Application No: R/156/20/PL
Site Address: 31 Albert Road Rustington BN16 3JT
Description of works: Extension and alteration of existing residential dwelling and subdivision to form 2no. two bedroom residential dwellings, together with formation of new vehicular access and entrance drive.

Thank you for your internet representation made on 18th September 2020 which has been recorded as an objection with the comments as follows:

DRAWING TITLE
PROPOSED ELEVATIONS

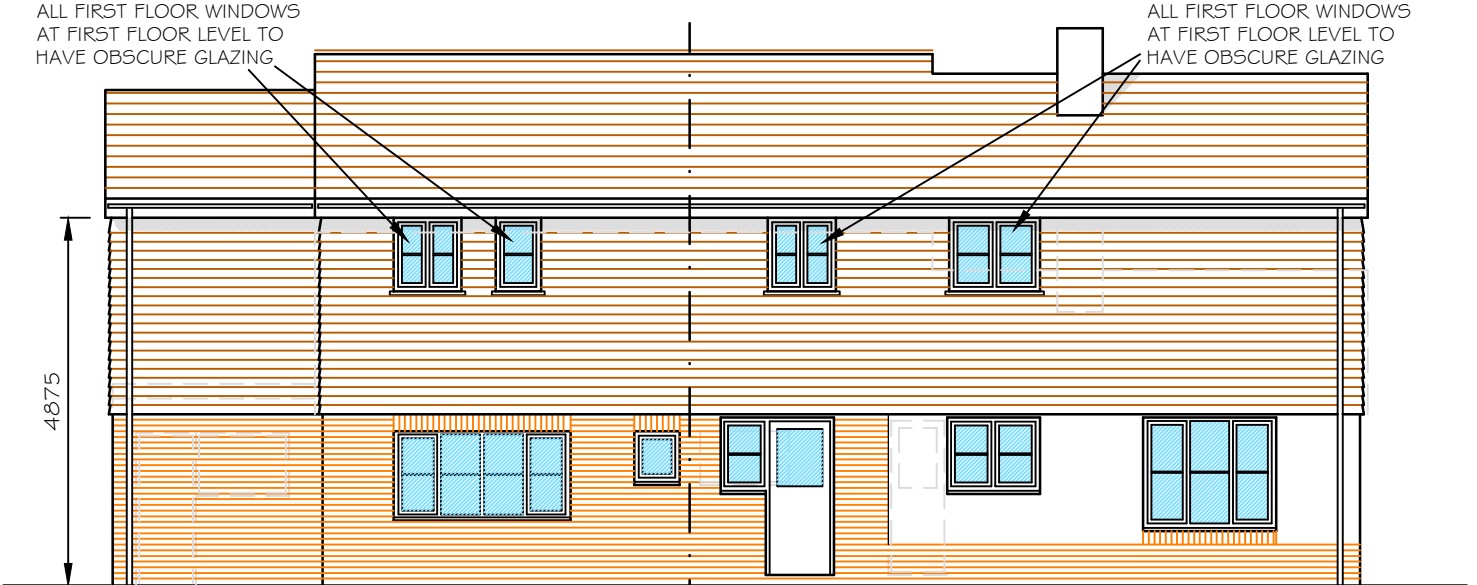
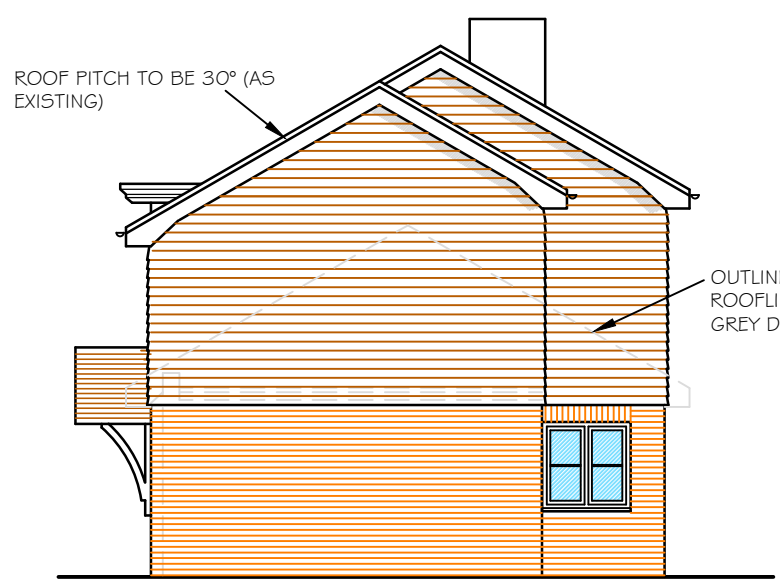
- (ii) The proposal, by reason of its height and mass, would represent an over-bearing form of development, which would have a detrimental effect on the visual amenities and quiet enjoyment of the occupiers of No. 29 Albert Road and No. 23 Mill Lane

DRAWING TITLE
SITE LOCATION AND BLOCK PLANS

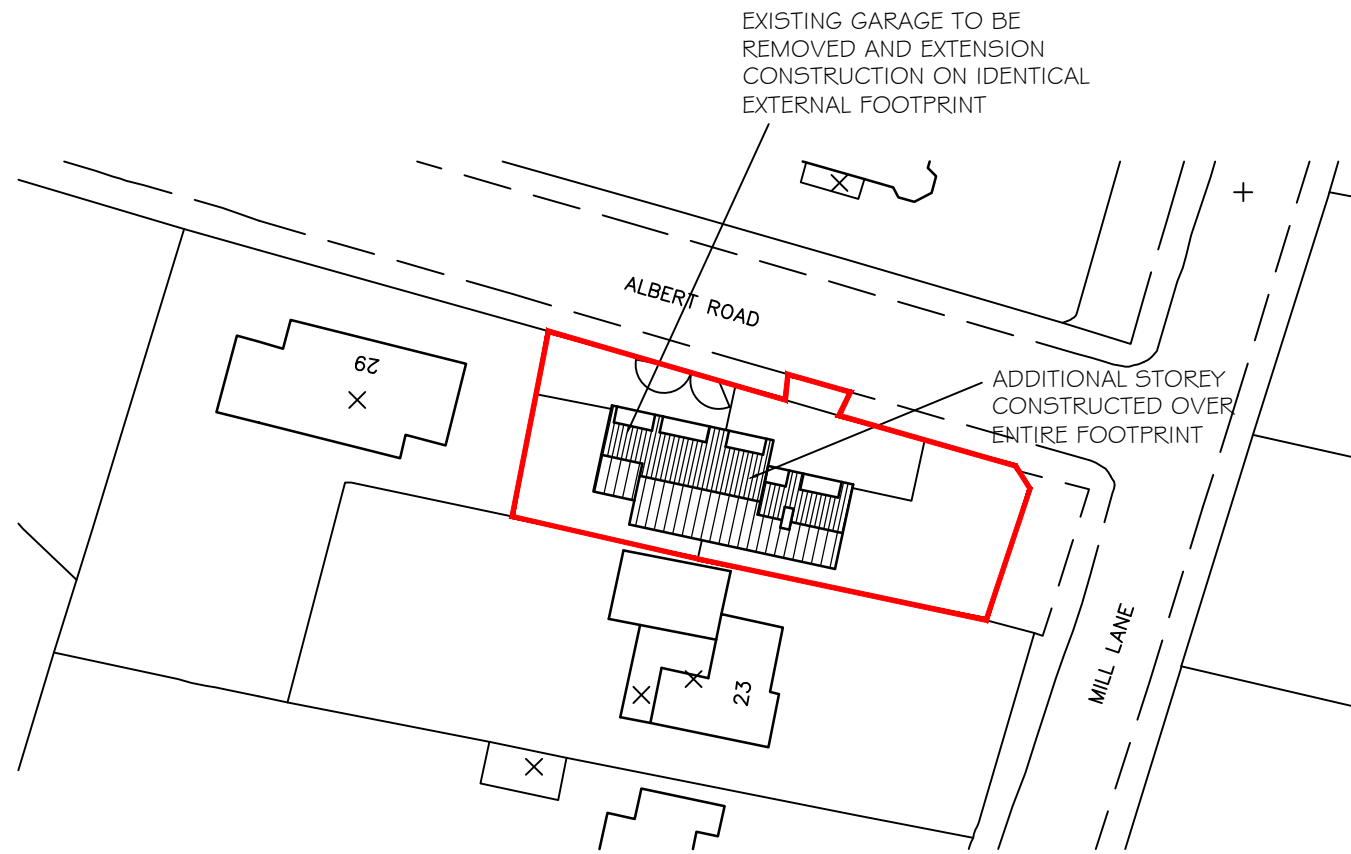
- (i) The size and shape of the plot would not permit development of a standard compatible with the existing development in the area and, in consequence, the proposal would be detrimental to the present character and amenities of the locality and would most certainly represent an over-development of the site
